3 Andrew Close

Re: - Loft Conversion, 31 Andrew Close - R/121/15/CLP

Drawing:
DESIGN PROPOSALS 2

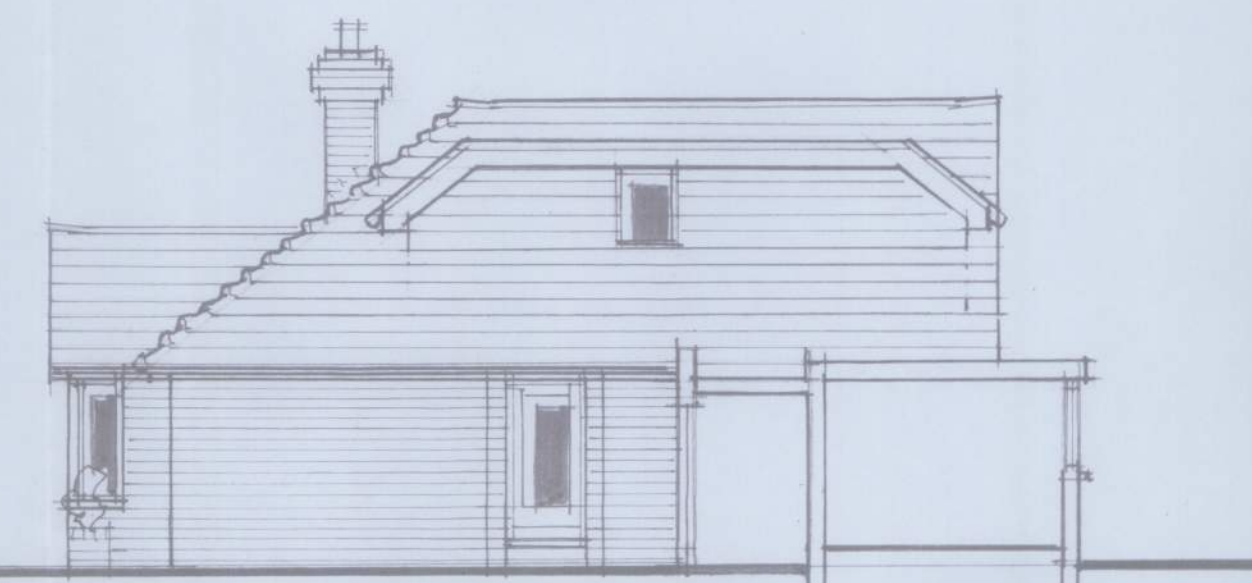
I wish to register strong objections to the proposed roof extension, albeit now deemed "lawful". The editions to the East and West elevations have hardly been altered and the large alteration to the North elevation is out of all proportion to the property and will adversely affect several bungalows in Barnside Gardens. I think the householders there will struggle to live happily with this invasion into their privacy.
